**Sikh Grammar School Rouse Hill (SSD-9472)
Request for Additional Information**

I refer to State Significant development application for the Sikh Grammar School Rouse Hill (SSD-9472). After careful consideration, the Department is requesting that you provide the following additional information:

CONSTRUCTION STAGE 7 - BASEMENT PARKING - SITE PLAN
ESTIMATED COMPLETION JAN 2039

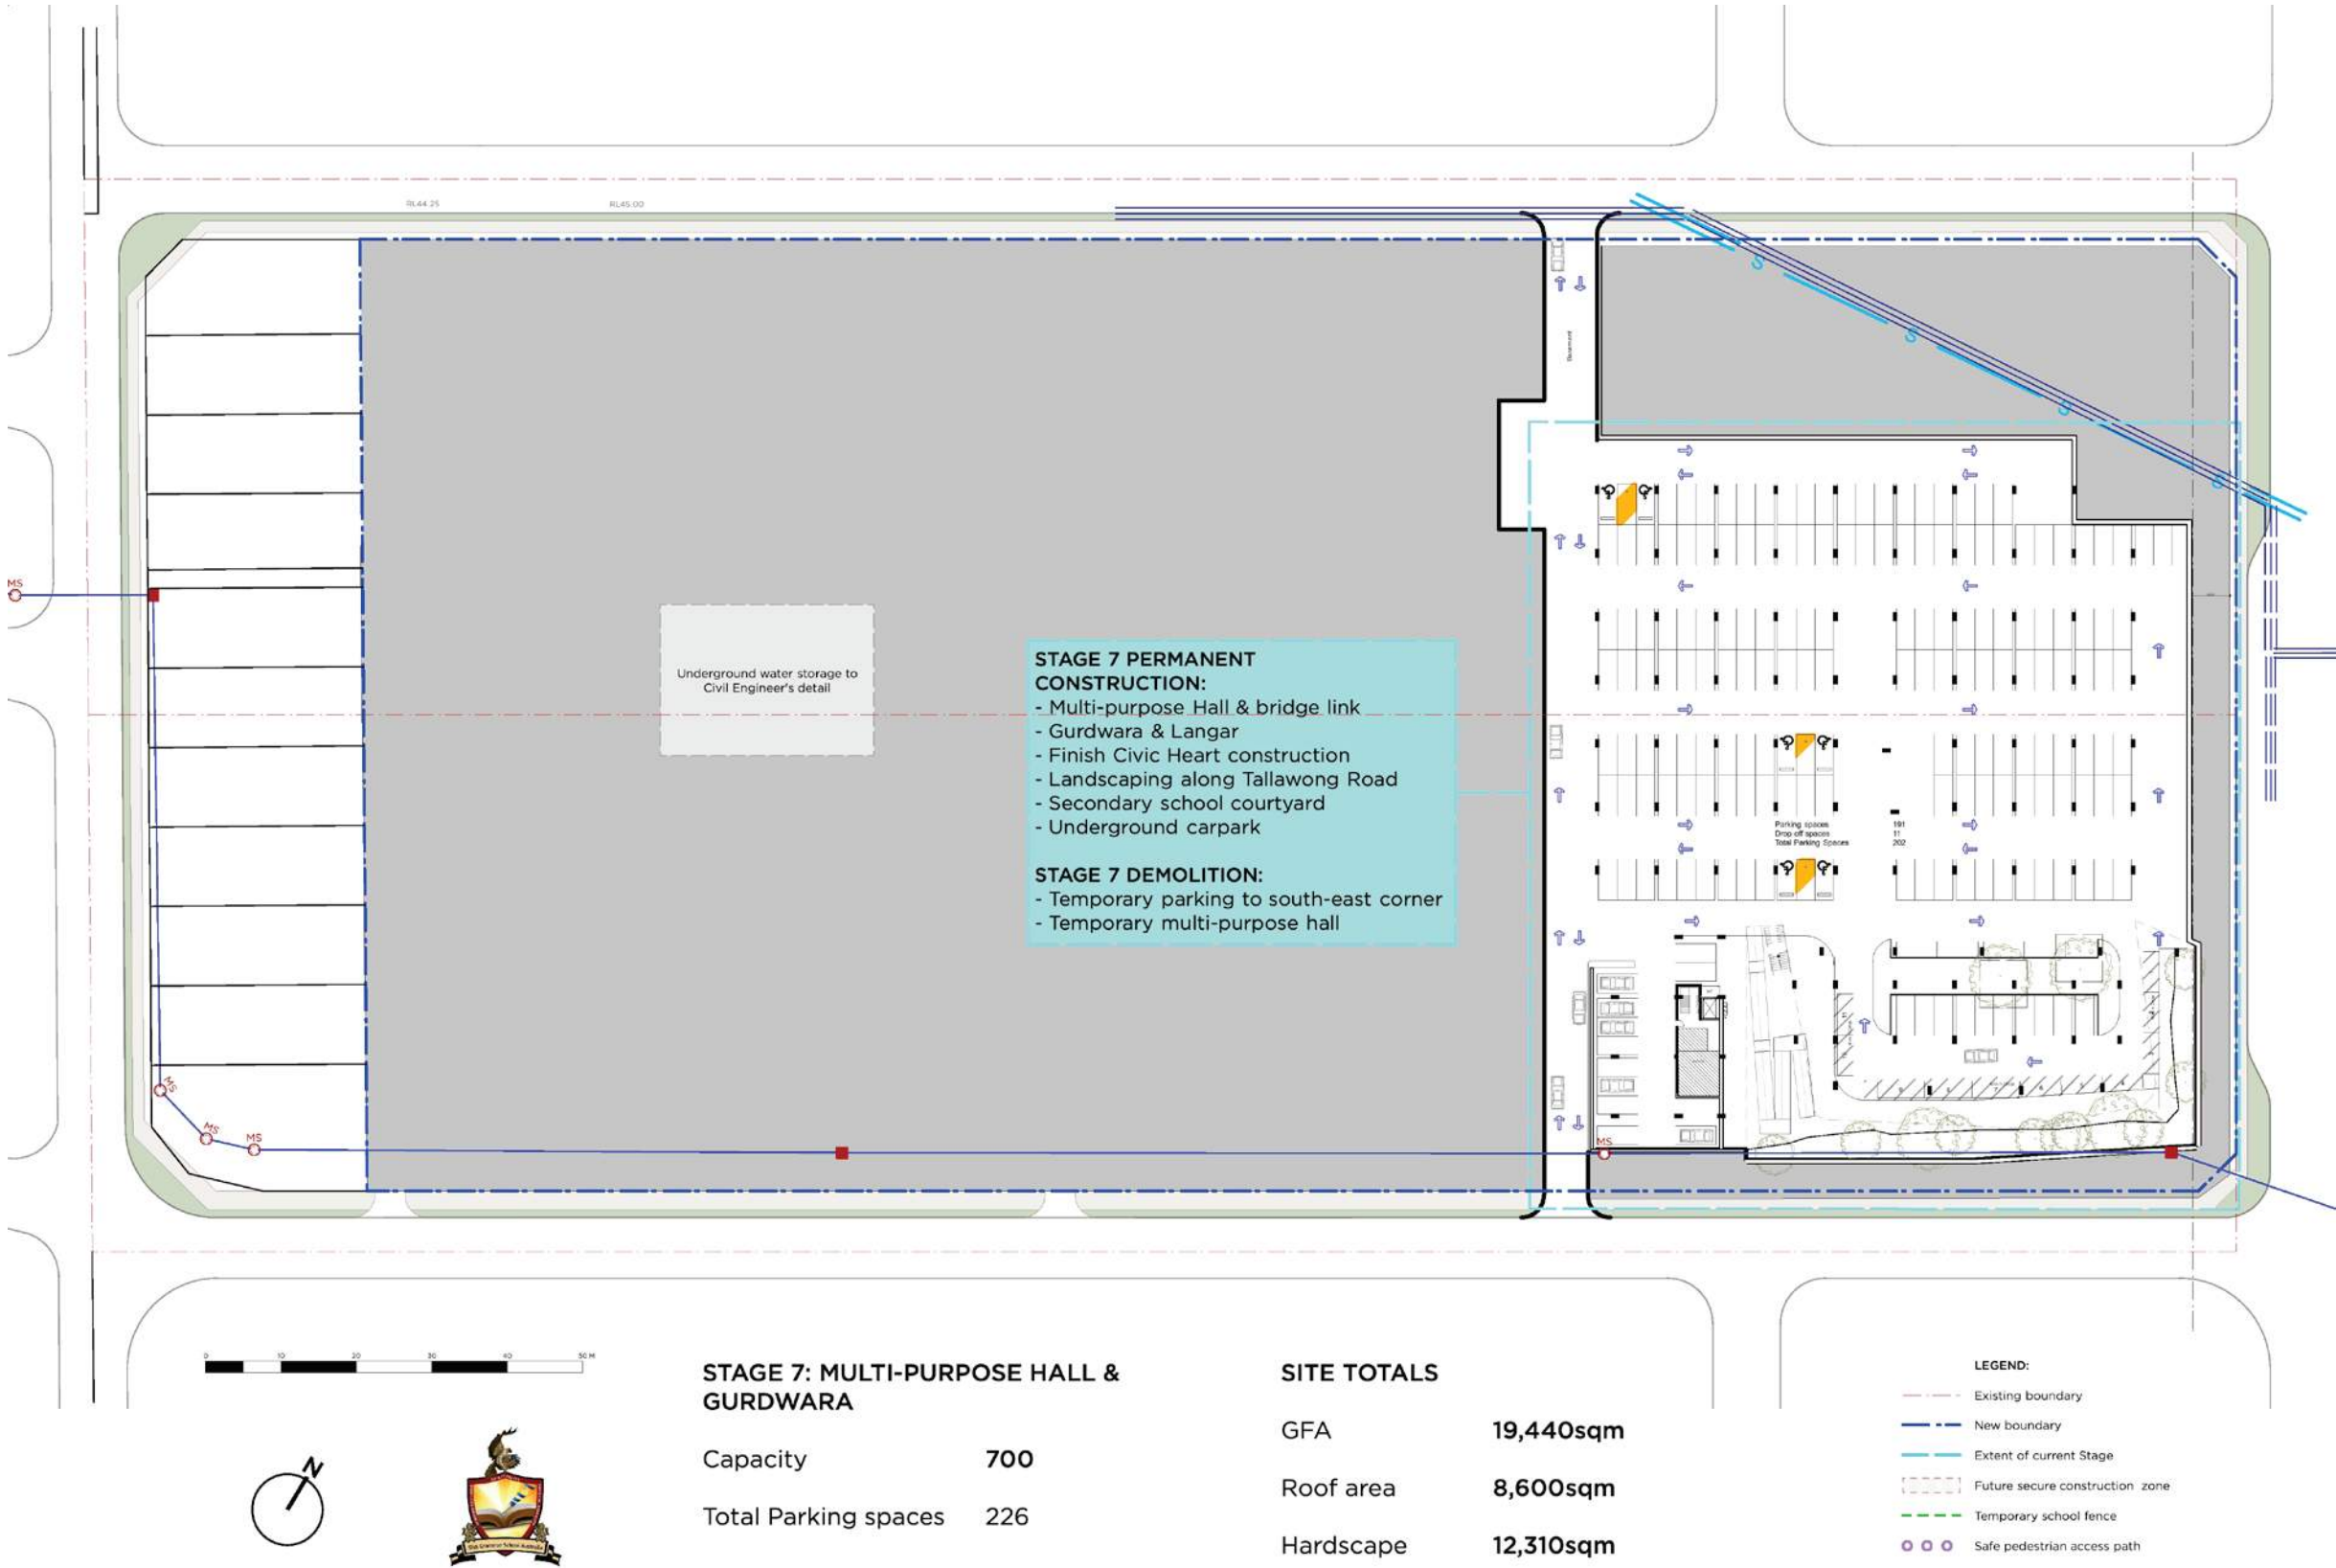
- the plan for Stage 4 shows an additional 40 on ground spaces and 10 drop-off / pick-up spaces at the south-eastern corner. This is not reflected in the traffic report.
- the traffic report states that the under-ground drop-off / pick-up area would be delivered in Stage 5 whereas the Staging plan says it would occur in Stage 7.

The Staging Table in the Table 4 of the Traffic Report notes that on-site drop-off / pick-up is proposed in **Stage 5** of the development and then an underground car park in **Stage 7**. However, the proposal would accommodate up to 900 school students before that. No information has been provided in the Traffic Report to indicate how many temporary drop-off / pick-up spaces are provided within the site till the time the underground carpark is delivered.
